Ribble Valley Borough Council
Church Walk,
Clitheroe,
BB7 2RA

Phone: 0300 123 6780
Email: lhscustomerservice@lancashire.gov.uk
Your ref:
Our ref: LHS/CS/3/2016/0146
Date: 17th May 2016

Proposal:	Outline application with all matters reserved for residential development of 23 dwellings , with access, parking and associated landscaping following demolition of Nos.23 25 Old Row
Location:	Old Row Whalley Road Barrow BB7 9AZ
Grid Ref:	373855 - 438540

Plan showing the approximate location of Public Footpath No. 1 Wiswell, Ribble Valley

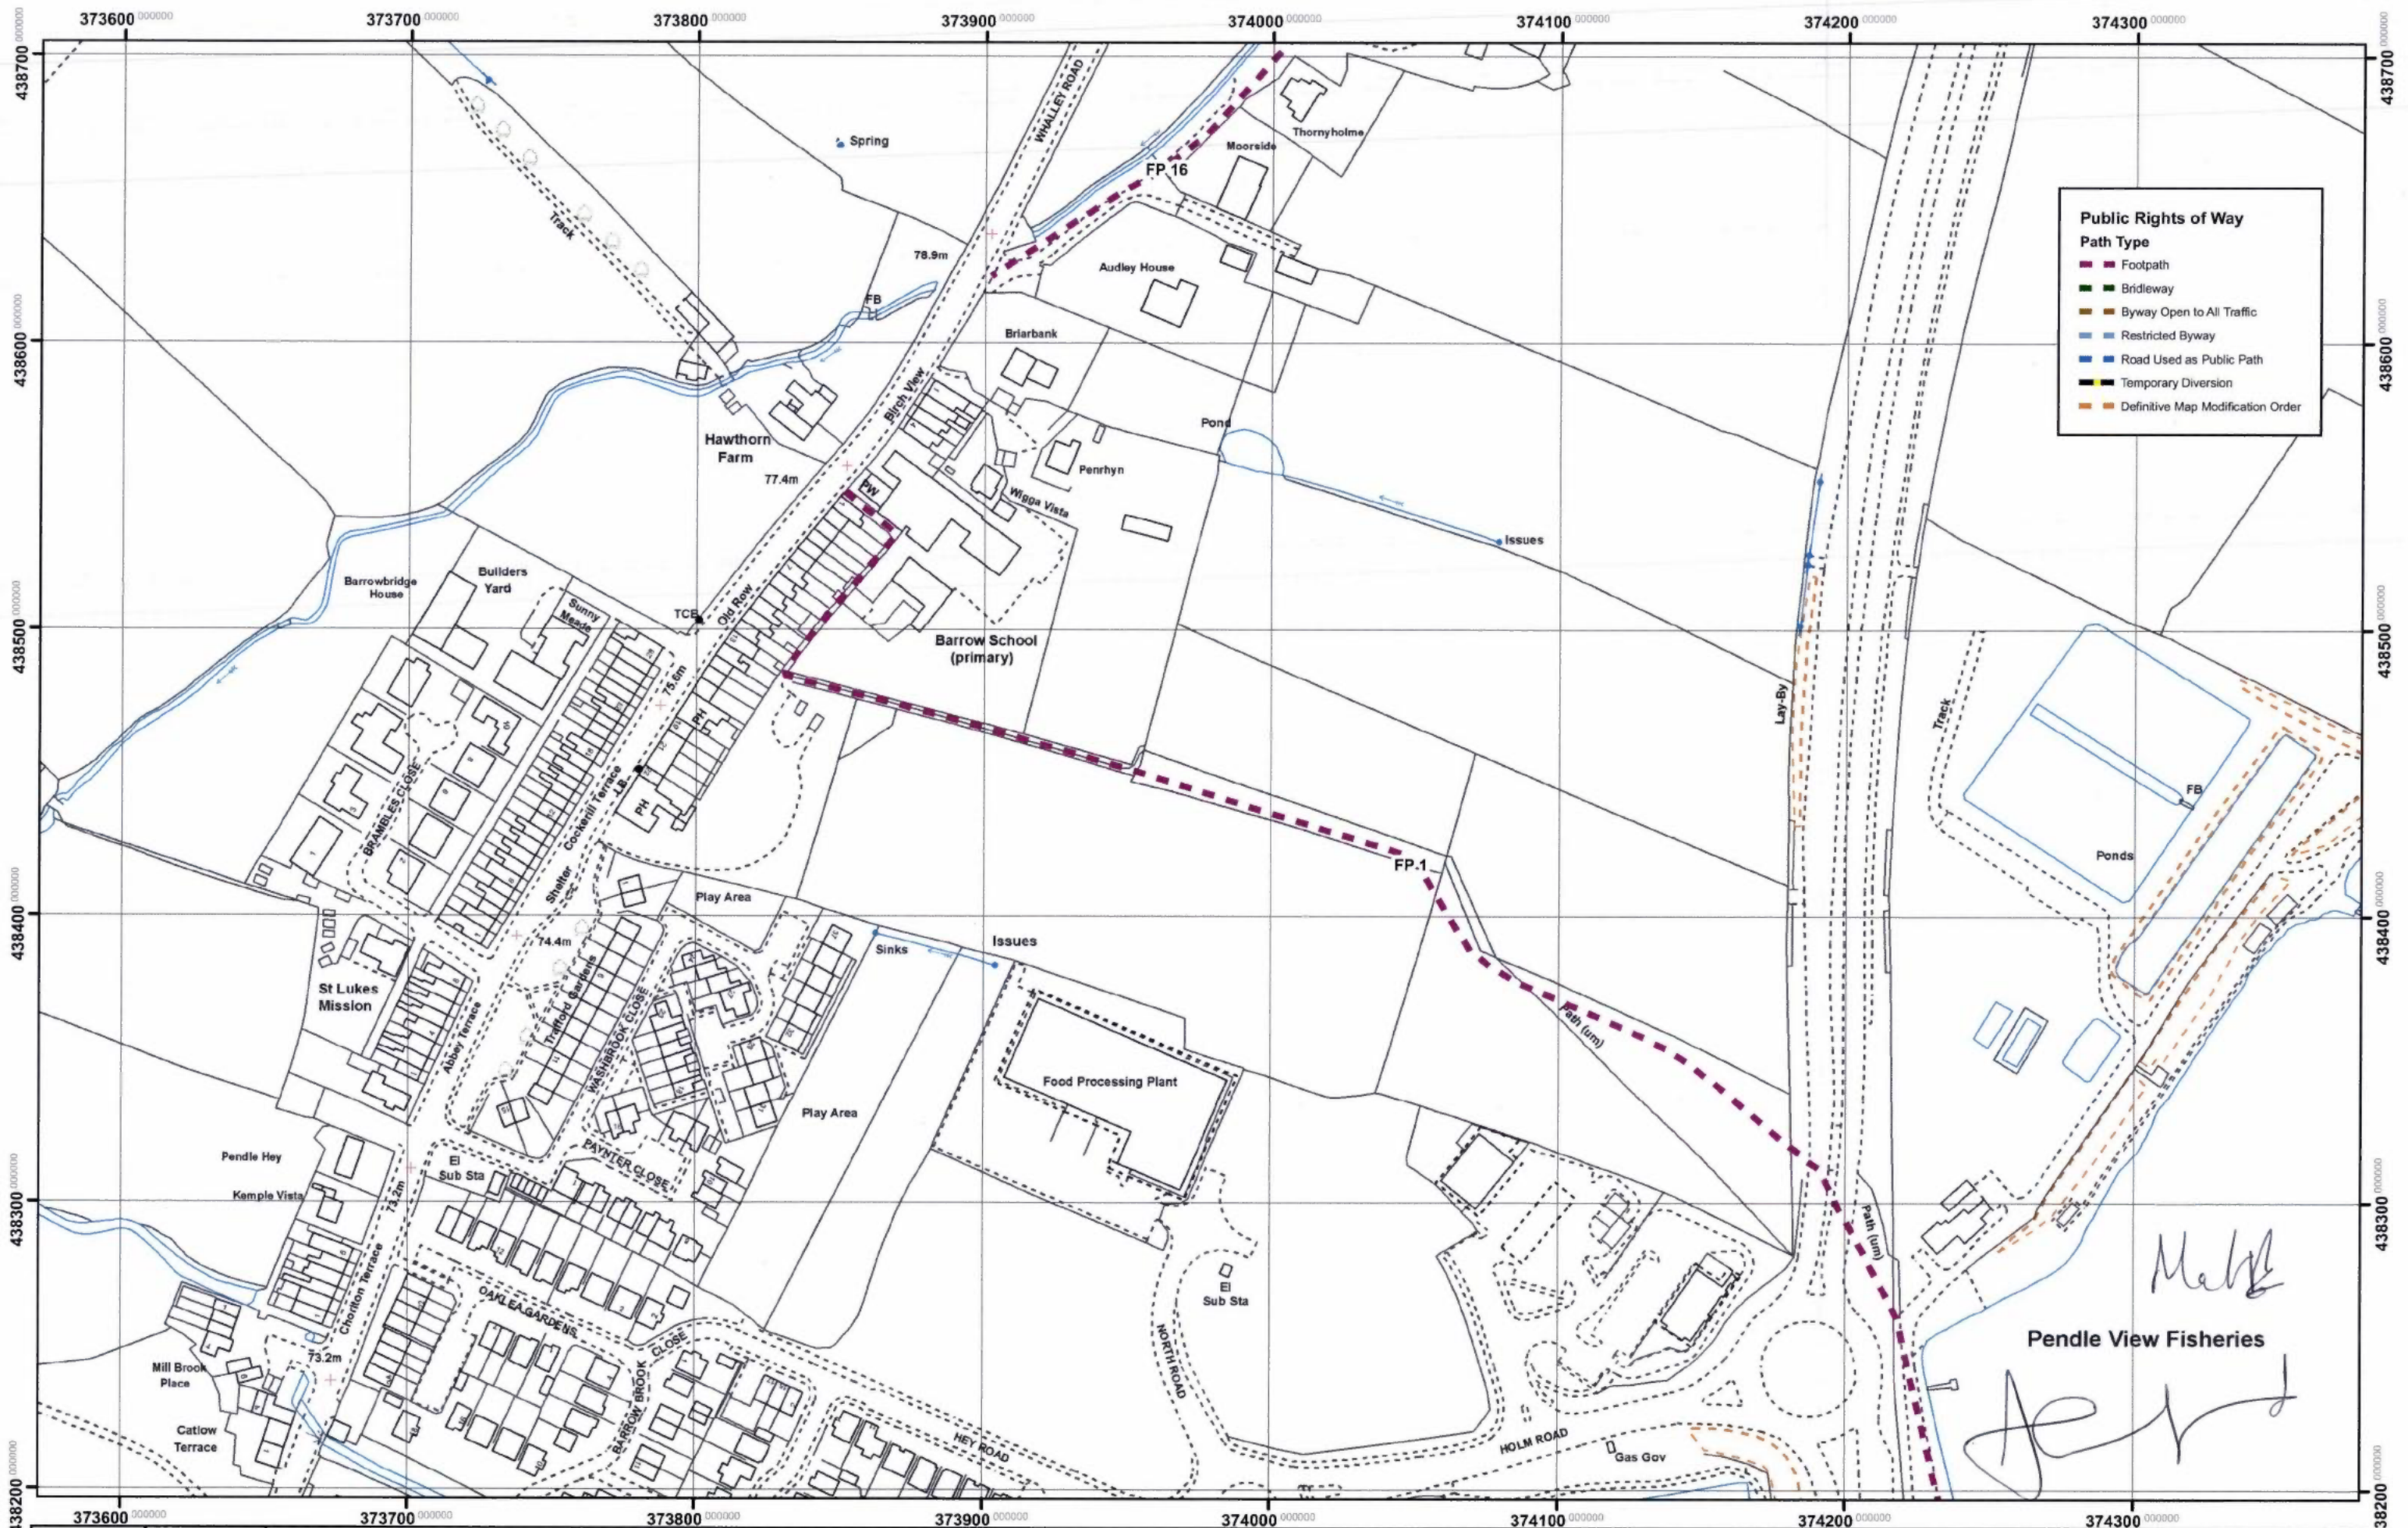
From or mapping system "Mapzone", the proposed development will have direct access along definitive footpath 3-47-FP 1 is to the north of the site boundary. The Lancashire County Councils Public Rights of Way Section to be consulted regarding required works to this route and connections from the site.

To support sustainable transport and improve social inclusion within the vicinity of the site, in addition to the bus stop improvements the Highway Development Control Section recommends section 106 highway contribution of £10,000 for improvement to the public right of way 3-4-FP 1 to the north of the site.

* Bus Stops to be upgraded to Quality Bus Stop Standard.
Details to be agreed as part of Section 278 agreement.

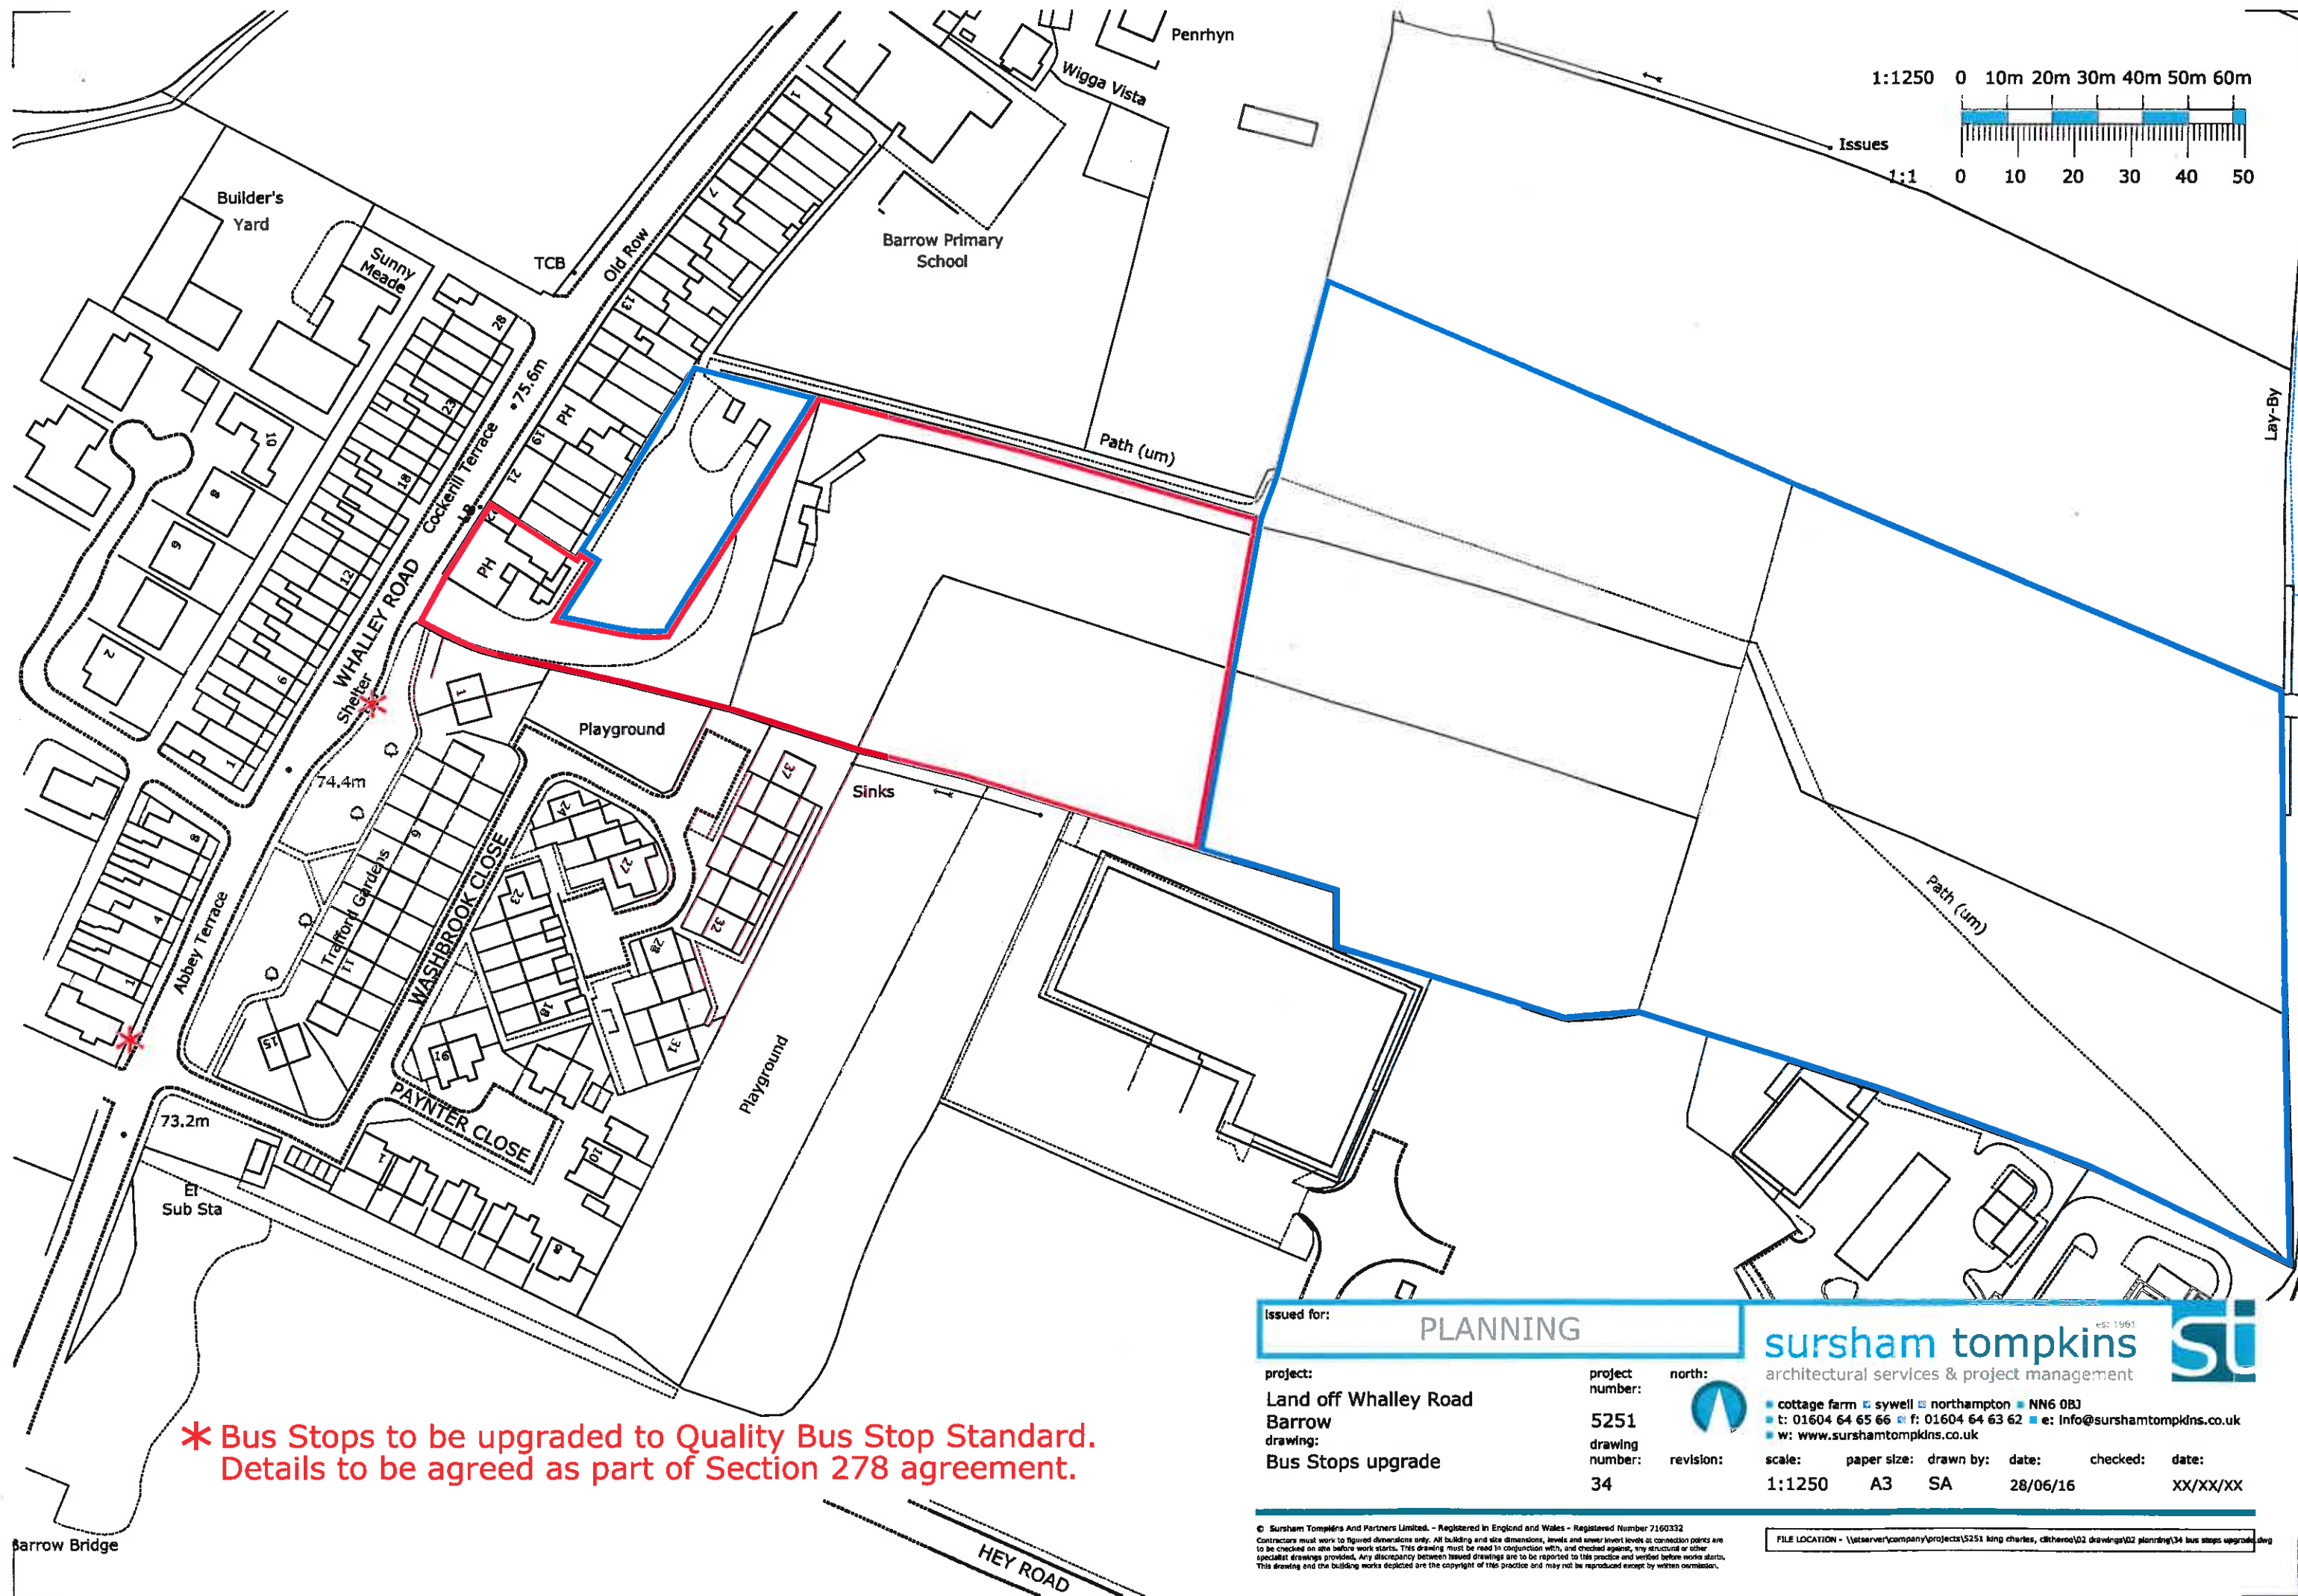
To support sustainable transport and improve social inclusion, the Highway Development Control Section recommends the upgrade the two bus stops adjacent to the site to be quality bus stops. The bus stop upgrade works area also to be done under a section 278 agreement with Lancashire County Council. The applicant should provide a plan showing the works required to improve the bus stops, before determining the application, to ensure local residents are aware of the improvements.
